**PLANNING APPLICATION Ref: 3/2021/0660 - Haweswater Aqueduct Resilience Programme
Proposed Bowland Section (Ribble Valley Borough Council)**

PROPOSED DEVELOPMENT: *Proposed works for and use of replacement section of aqueduct, including earthworks and ancillary infrastructure including: a new valve house building within fenced compound with permanent vehicular access provision. With the installation of a tunnel portal and an open cut connection area within a temporary construction compound, to include site accesses, storage areas, plant and machinery, and drainage infrastructure and a temporary haul route with bridge over the River Hodder. In addition, a temporary haul route with bridge over the River Ribble (as one of two options for vehicular access to the temporary construction compound); a series of local highway works together with a temporary satellite park and ride facility and a vehicle marshalling area.*

APPLICATION UPDATES

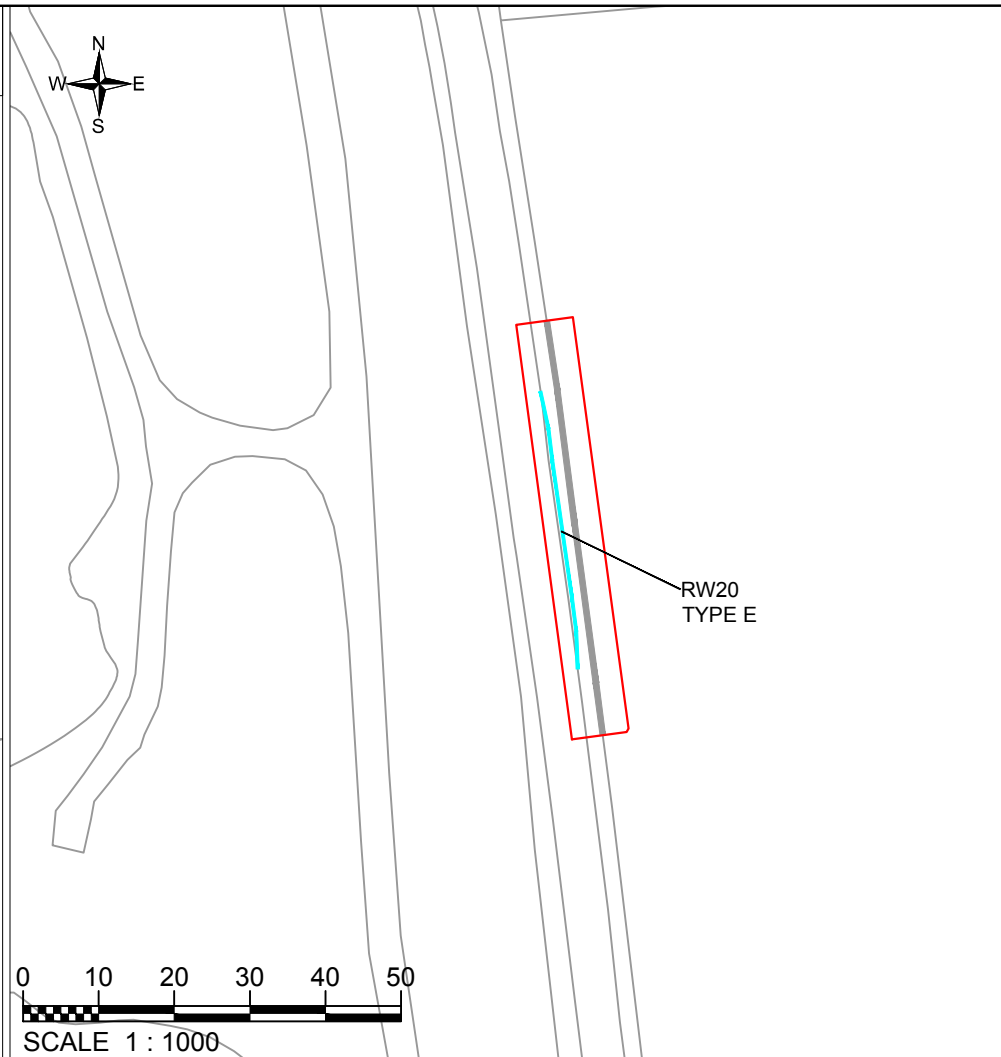
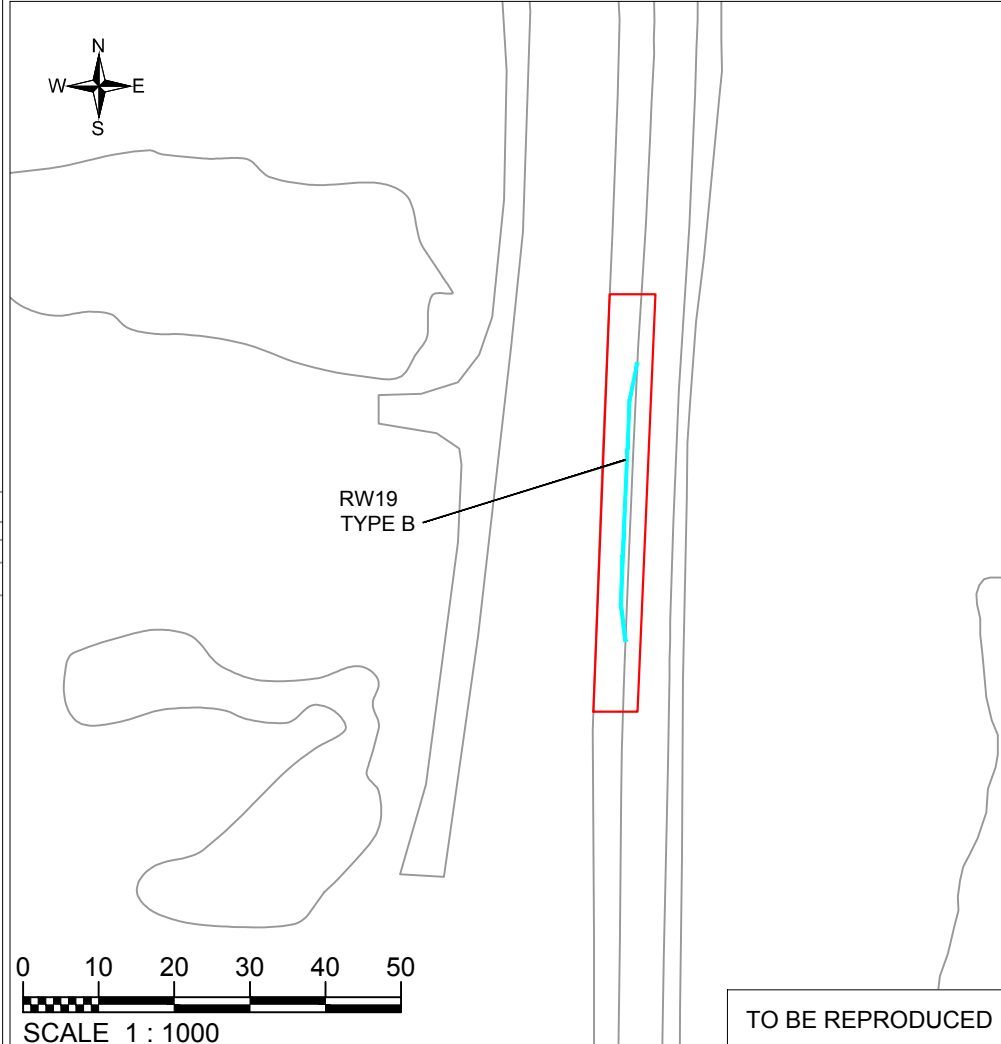
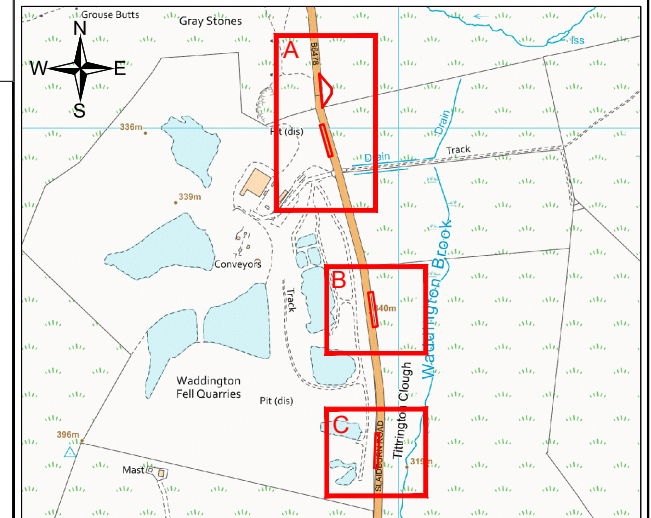
Further to the above, whilst Option 1 is in place, during the 9 month ‘enabling phase’, there would be a very infrequent requirement for HGVs to travel through Chatburn, Grindleton and West Bradford. On this basis, it is proposed that such movements would be managed without the need for the implementation of certain previously identified highway modifications: RW01 to RW07 inclusive, and therefore these are removed from the planning application and this is reflected in the updated Series 12 – Highways Works planning drawings.

SITE LAYOUT
(SCALE 1:2500)

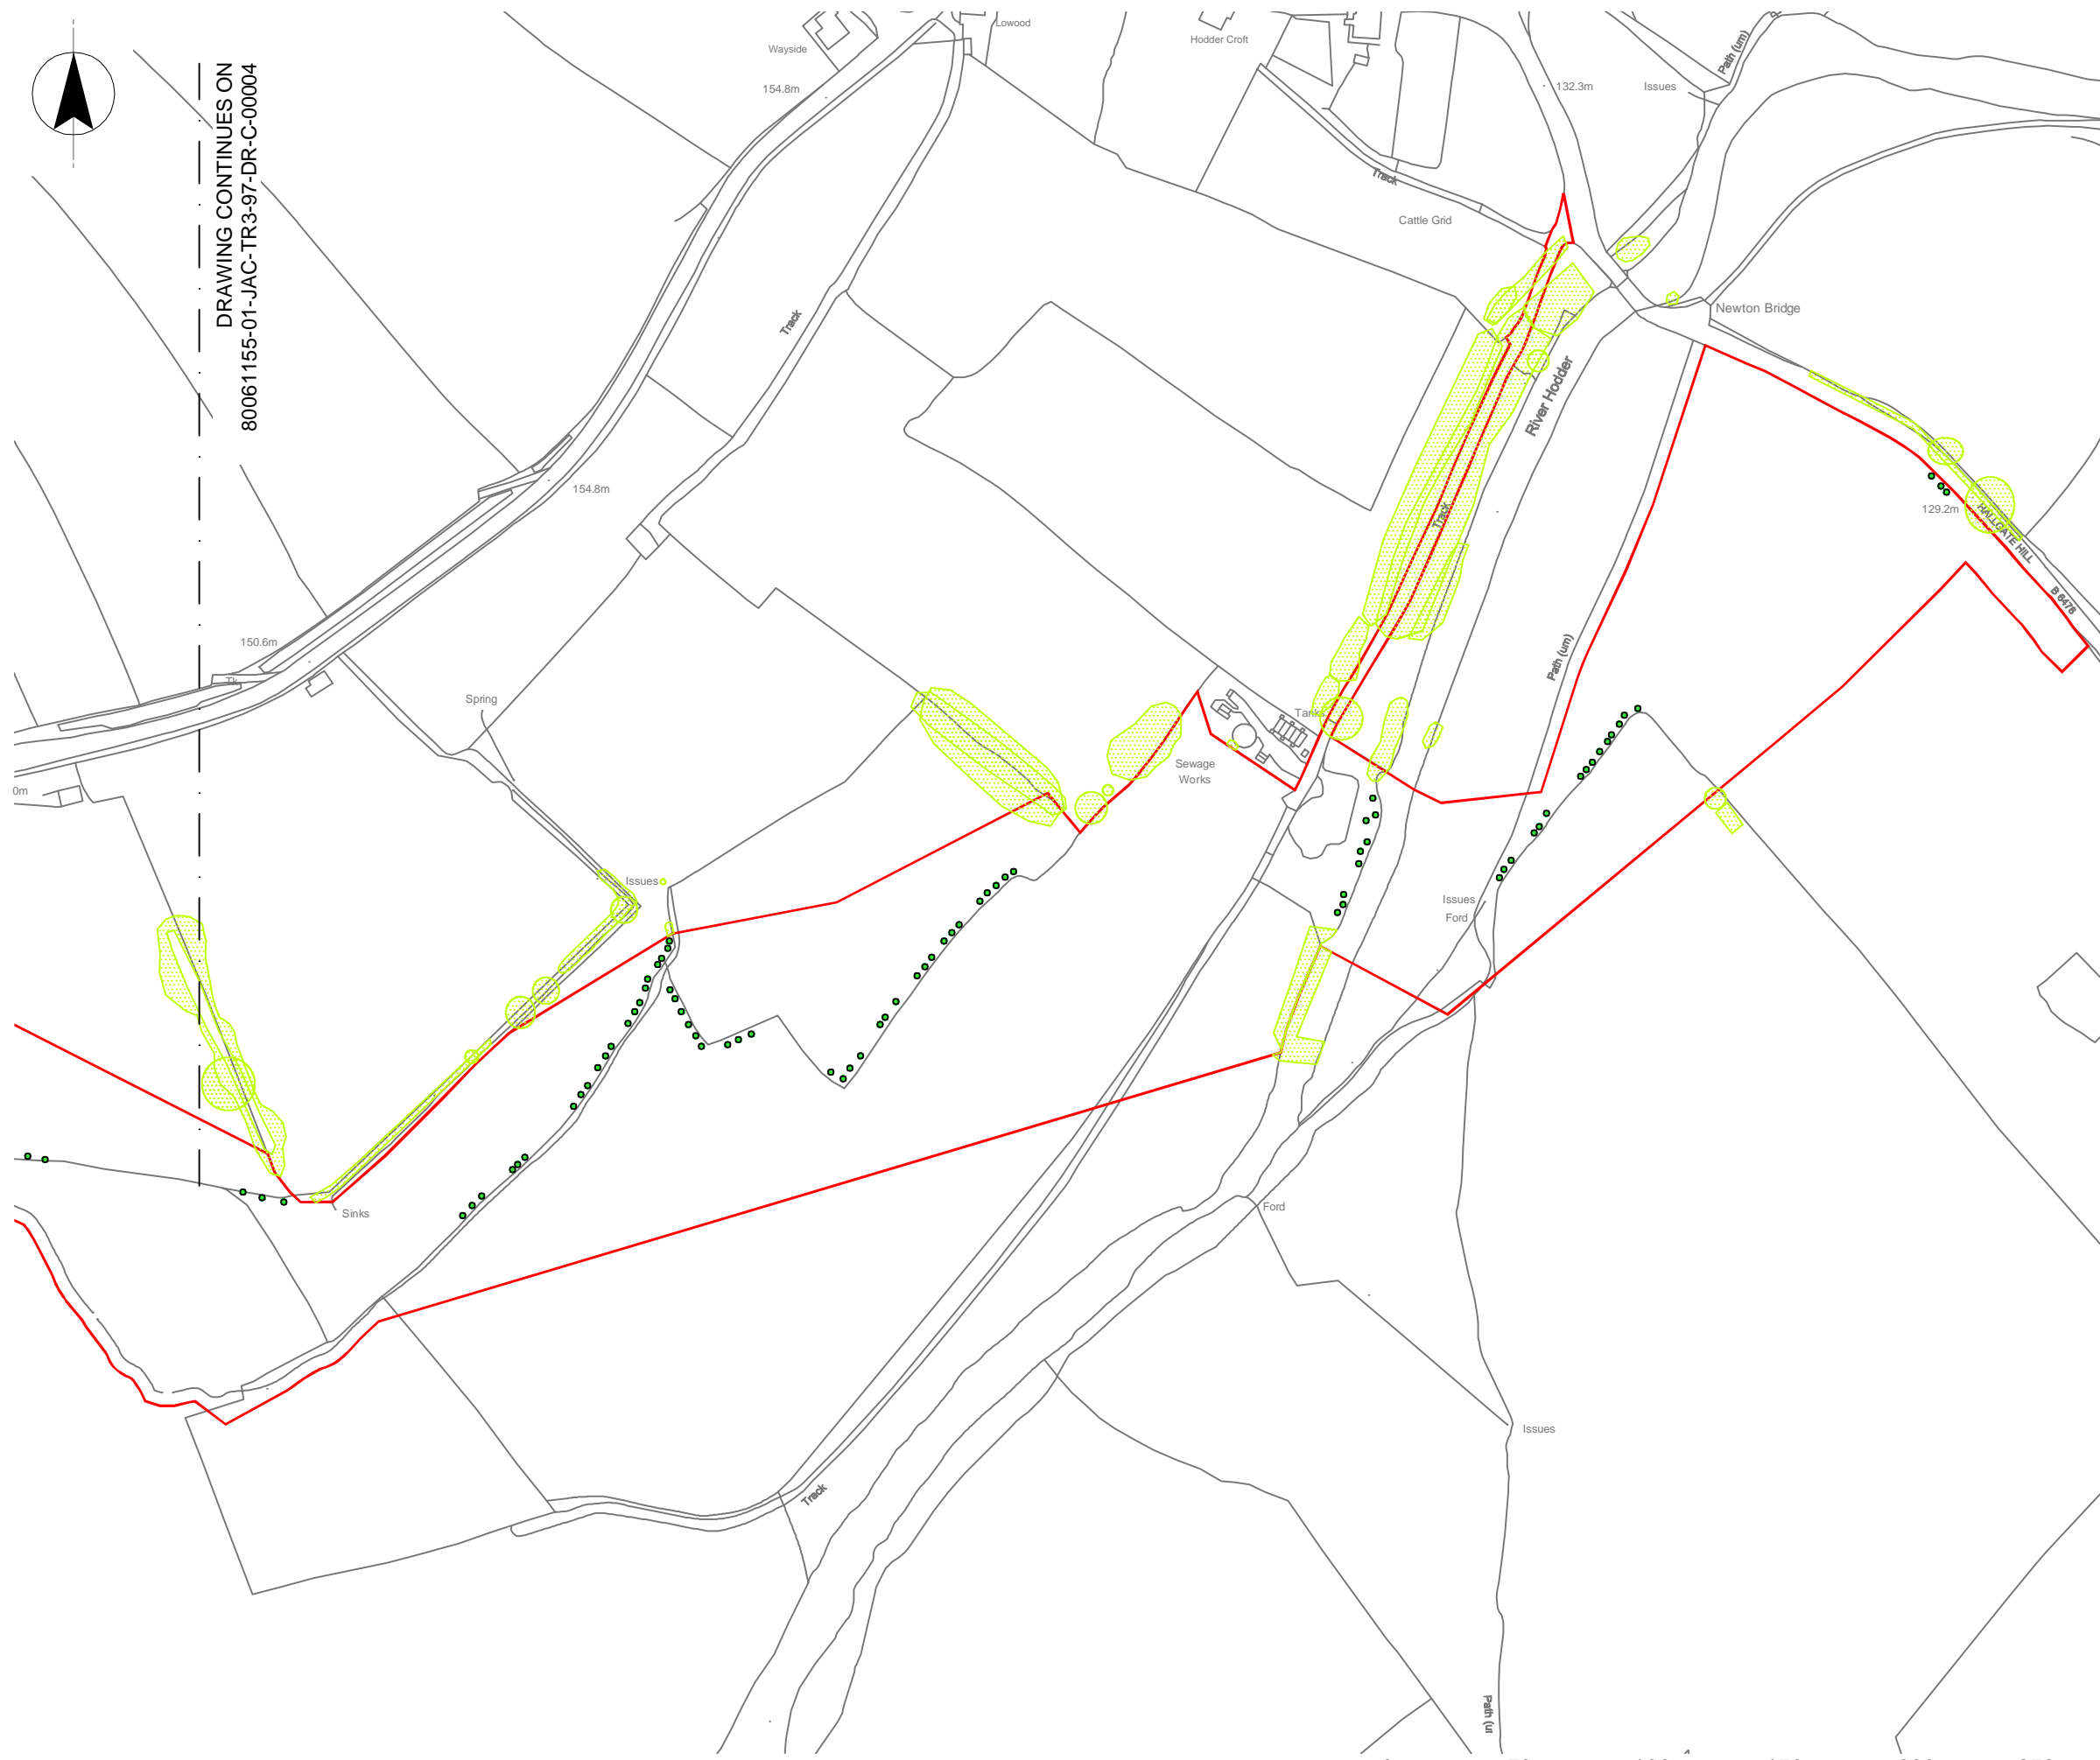
Avoidance of some previously affected trees within the Newton-in-Bowland Compound through embedded mitigation proposals (i.e. avoidance through design), and these are reflected on the updated Series 3 - Site Layout Plans.
